Arun District Council
Arun Civic Centre
Maltravers Road
Littlehampton
West Sussex BN17 5LF
Planning & Building Control General Enquiries
Tel: (01903) 737756 Fax: (01903) 730442
Dx: 57406 Littlehampton
Minicom: 01903 732765
e-mail: planning@arun.gov.uk
website: www.arun.gov.uk/planning

Application No: WA/63/21/PL
Site Address: Land East of Tye Lane Walberton BN18 0LU
Description of works: Proposed alternative vehicular accesses off Tye Lane and emergency access off Avisford Park Road, along with minor highway works following WA/95/18/RES (resubmission following WA/93/20/PL). This site is CIL Zone 2 (Zero Rated) as other development.

Drawing Title:
PROPOSED ALTERNATIVE ACCESS

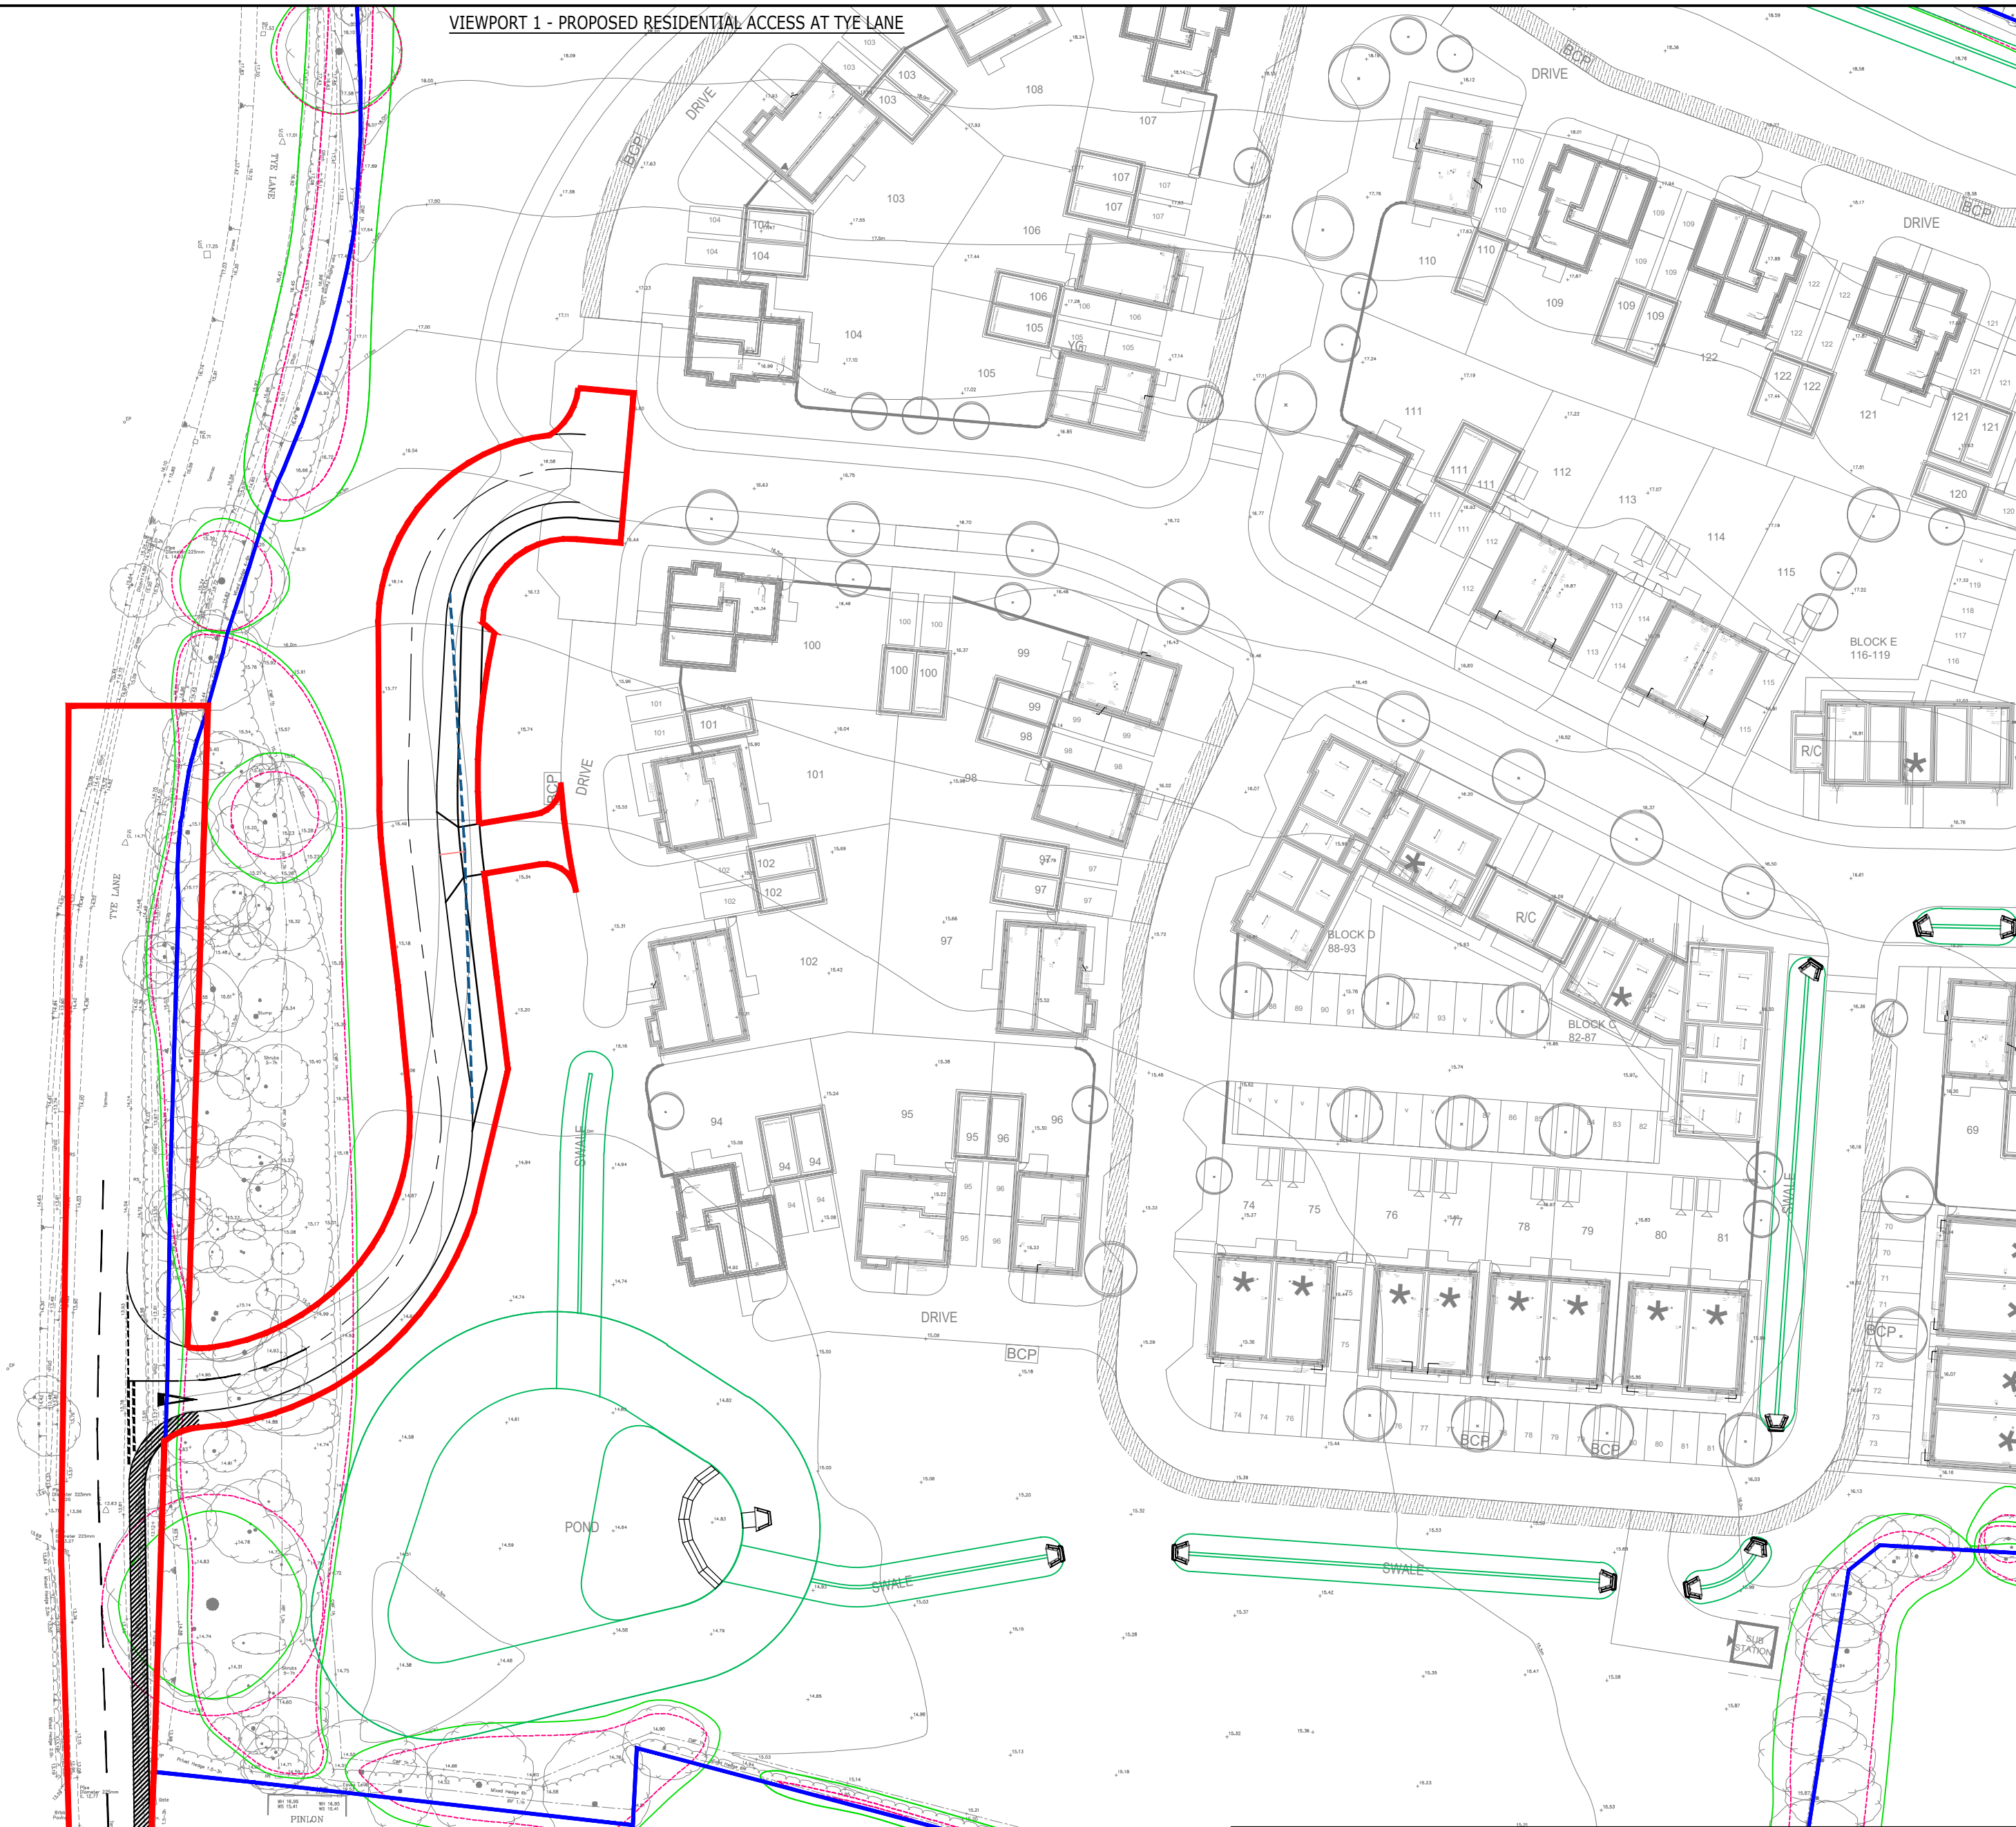
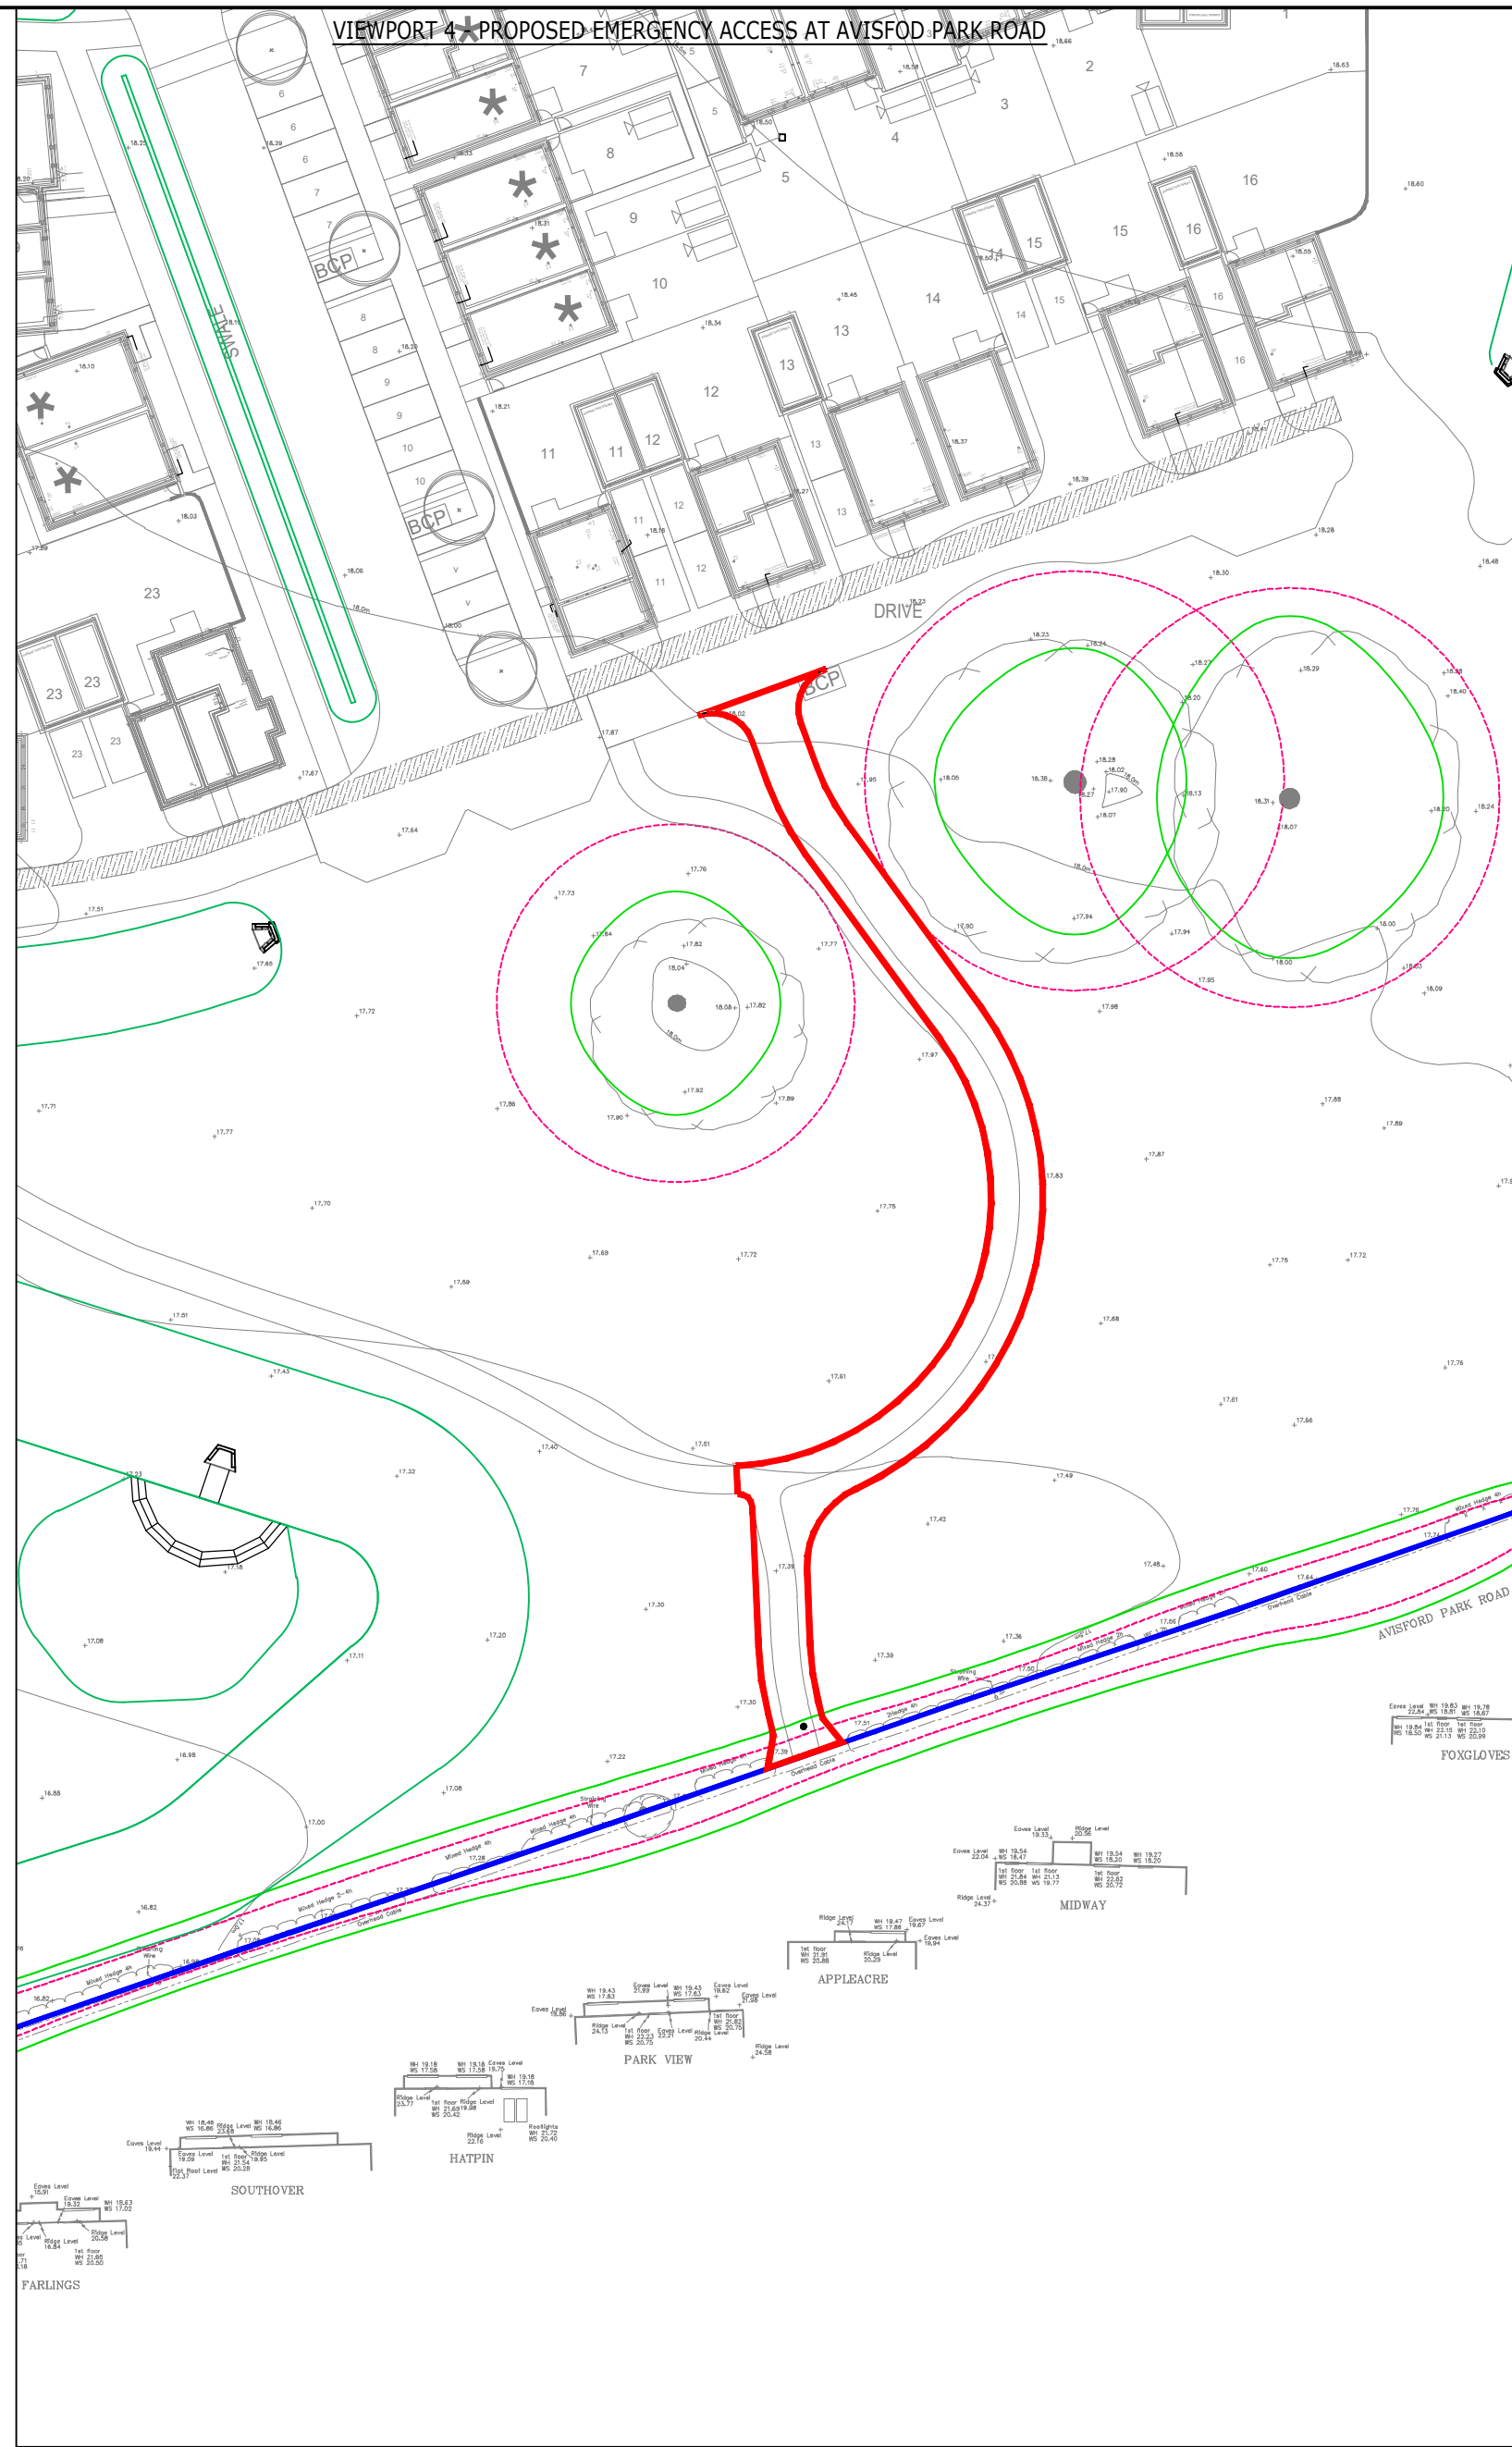
We reiterate that Avisford Park Road is an unsuitable and unsafe choice for this proposed emergency access. It is a public footpath, regularly used by dog walkers and parents walking small children to school. It is an unadopted no-through road maintained by residents at their own cost - its surface is fragile and pot-holed. Consequently, vehicles respect a 10mph speed limit and the council's refuse vehicles reverse down the road in order to drive slowly out. It is wide enough only for a single vehicle, and two vehicles cannot pass each other. It is frequently blocked by parked cars and delivery vehicles, and used for community street events. It could not be a more inappropriate proposal.

The single bollard at each end of the proposed emergency access is insufficient to prevent its use by vehicles such as motor cycles tempted by an obvious short cut onto Yapton Lane, putting the safety of pedestrians using the public footpath on Avisford Park Road at very high risk, particularly where the proposed emergency access meets the existing public footpath. With a proposed access width of 3.5 metres, it is possible that cars may also attempt unauthorised use as a short cut to and from the Avisford Grange development. This constitutes a material change to the original proposal and will adversely affect the character of this quiet, residential no-through road. An L-chicane should be installed at each end to ensure the safety of all users: this, of course, is incompatible with its use by emergency vehicles.

Any widening of the already approved path in order to facilitate use by emergency vehicles is likely to impinge on the (already agreed and approved) public open space and may impact the roots of the three protected trees. Both factors should render the proposal unacceptable.

Any additional lighting at the junction of the proposed emergency access with Avisford Park Road should be in accordance with Walberton Neighbourhood Plan Policy VE 8 'Unlit village' status.

Removal of established and existing hedgerow to accommodate access from Avisford Park Road would destroy wildlife habitat and nesting sites for birds as well as natural screening of the new development from Avisford Park Road. This is a material change from the approved application, with the existing estate fencing to be replaced with 'like for like'.
